DEVELOPMENT REVIEW BOARD - HYDROLOGY SECTION
 Renée Brissette, PE, Senior Engineer | 505-924-3995 rbrissette@cabq.gov

DRB Project Number: 2019-002058 Hearing Date: 01-15-2020
 Project: Lots 9-A & 10-A, Block "W", The Atlantic & Pacific Addition Agenda Item No: 10

PLAT OF  
**LOTS 9-A & 10-A, BLOCK "W"**  
**THE ATLANTIC AND PACIFIC ADDITION**  
 WITHIN  
 TOWN OF ALBUQUERQUE GRANT  
 PROJECTED SECTION 20, T.10N., R.3E., N.M.P.M.  
 CITY OF ALBUQUERQUE  
 BERNALILLO COUNTY, NEW MEXICO  
 MAY, 2020

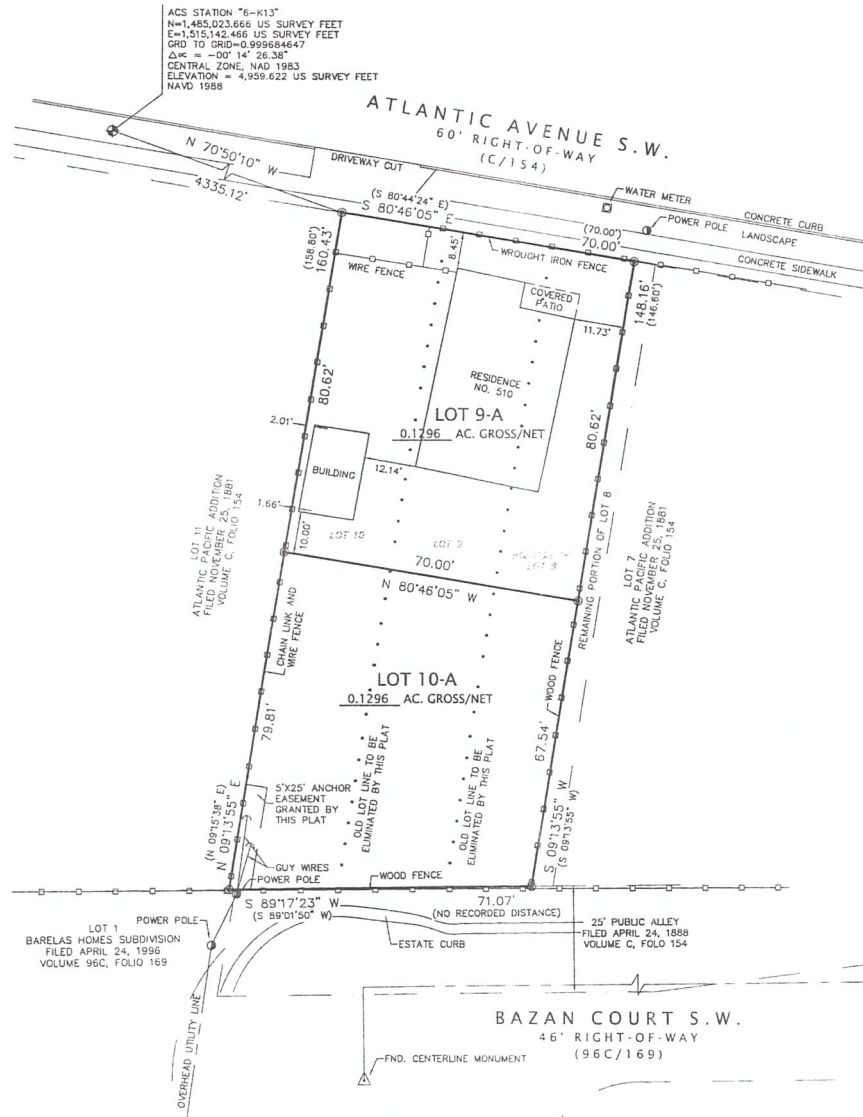
- Hydrology can approve the Preliminary Plat with either a Cross Lot Drainage Easement note specifying the beneficiary and maintenance agreement or a block wall separating the two lots so that the drainage from Lot 10-A does not go onto Lot 9-A since both lots are in the valley and need to a hear with DPM Chapter 22 Section 5.G (Flat Grading Scheme).
- Comment - Lot 10-A will need an approved Grading and Drainage Plan is required prior to Building Permit if one of these conditions is met. (500 cy of grading, 1,000 sf of proposed building, or 10,000 sf of proposed paving). Also the Grading and Drainage Plan will have to follow the DPM Chapter 22 Section 5.G (Flat Grading Scheme).
